From: Iain Osenton <iain.osenton@cherwell-dc.gov.uk>
Sent: 31 May 2022 15:39
To: Planning <Planning@Cherwell-DC.gov.uk>; dcregistration <dcregistration@Cherwell-DC.gov.uk>
Cc: David Lowin <David.Lowin@Cherwell-DC.gov.uk>
Subject: 22/01144/F - CDC Arboriculture

Please see below from desk based assessment my initial observations.
Comment – More information required.

| Plan EDP 2 | Tree Retention and Removal Plan – Drainage Strategy

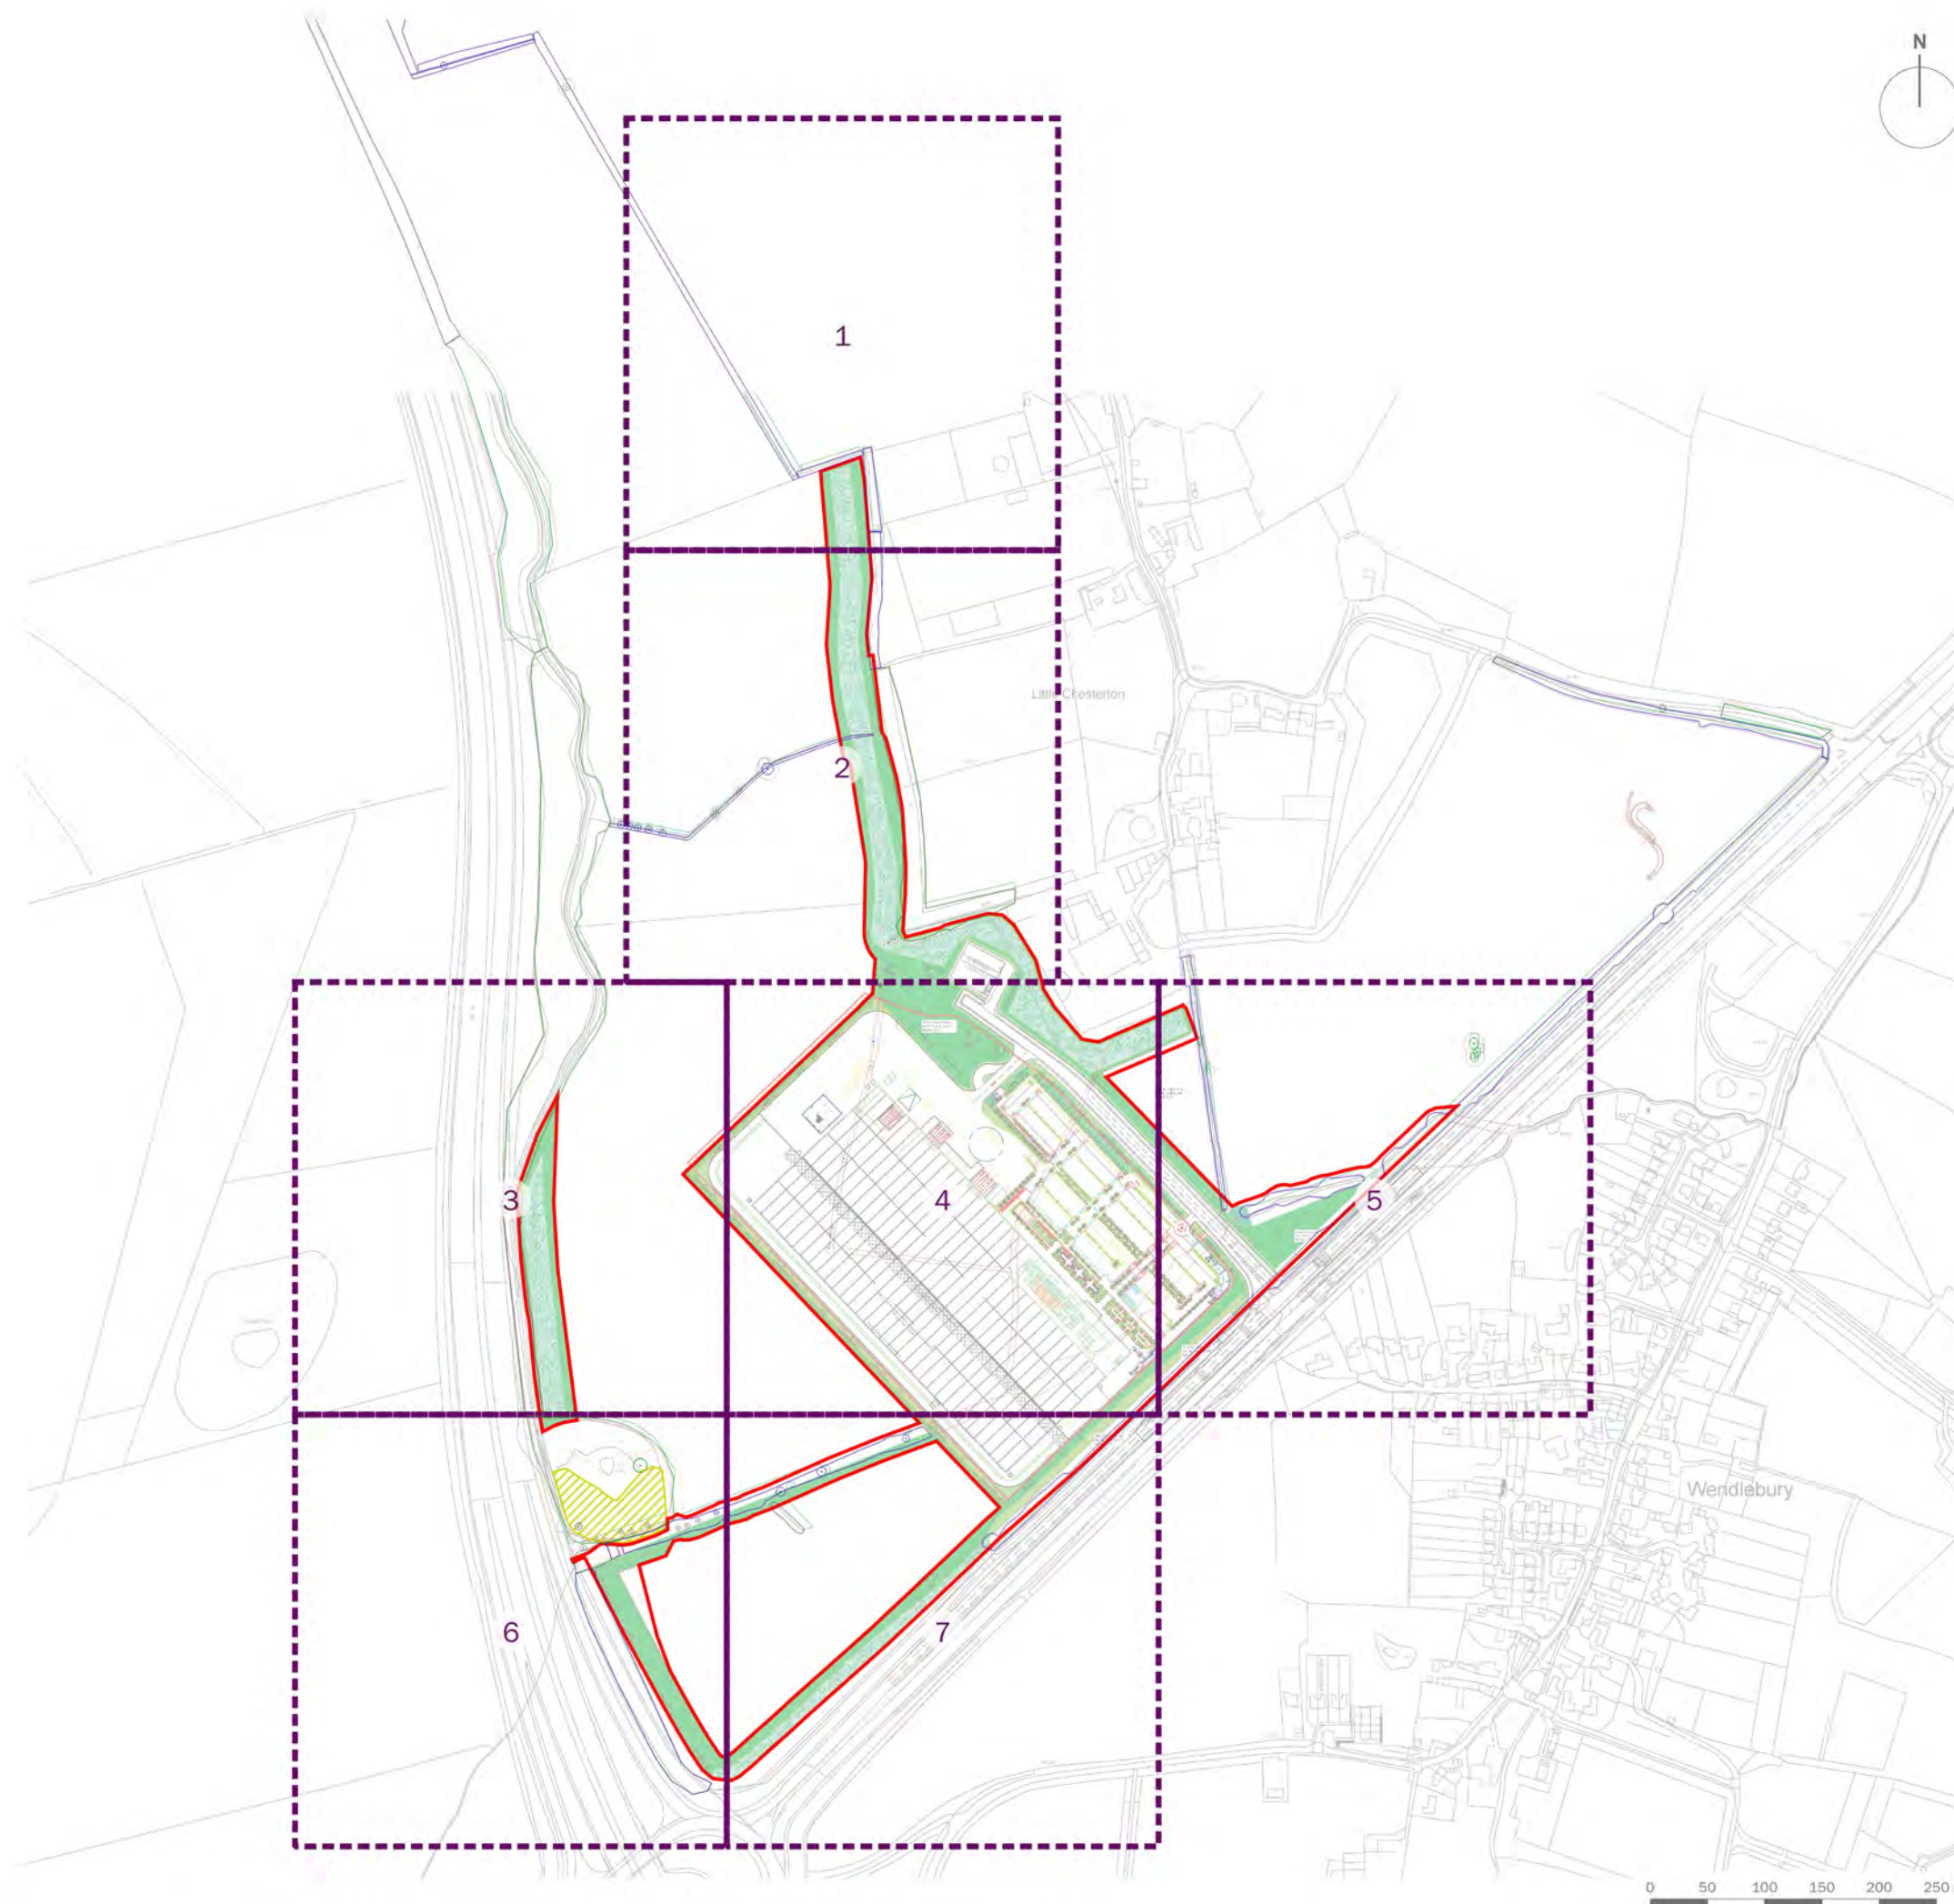
An AMS is included within the report however, some further details will be required. It is acknowledged some of this information is likely unavailable currently. 3.14 states service locations, whilst remaining outside RPAs are subject to confirmation from the applicant. The AMS does not include a plan demonstrating tree protection fencing, though it is acknowledged the majority of vegetation sits outside the area of development. The AMS does not include a methodology for working within the ancient woodland buffer for redirecting drainage, and does not include details such as the site compounds location mentioned in 3.20.

- The site holds no public access. Where the WMP outlines removal of structurally compromised trees, detail is required under what criteria is a tree considered structurally compromised. The woodland holds no public access as such removal of trees with cavities etc. would reflect a removal of habitat key for woodland biodiversity.
- The WMP proposes removal of invasive species. Species proposed for removal will need identifying and quantifying.
- The WMP mentions planting, but, this is not included in the management programme, nor is detail given to planting within, or upon the border/buffer. If trees are proposed for removal, replanting will certainly be a requirement, as will replanting in the buffer area which will see removals in order to redirect drainage.
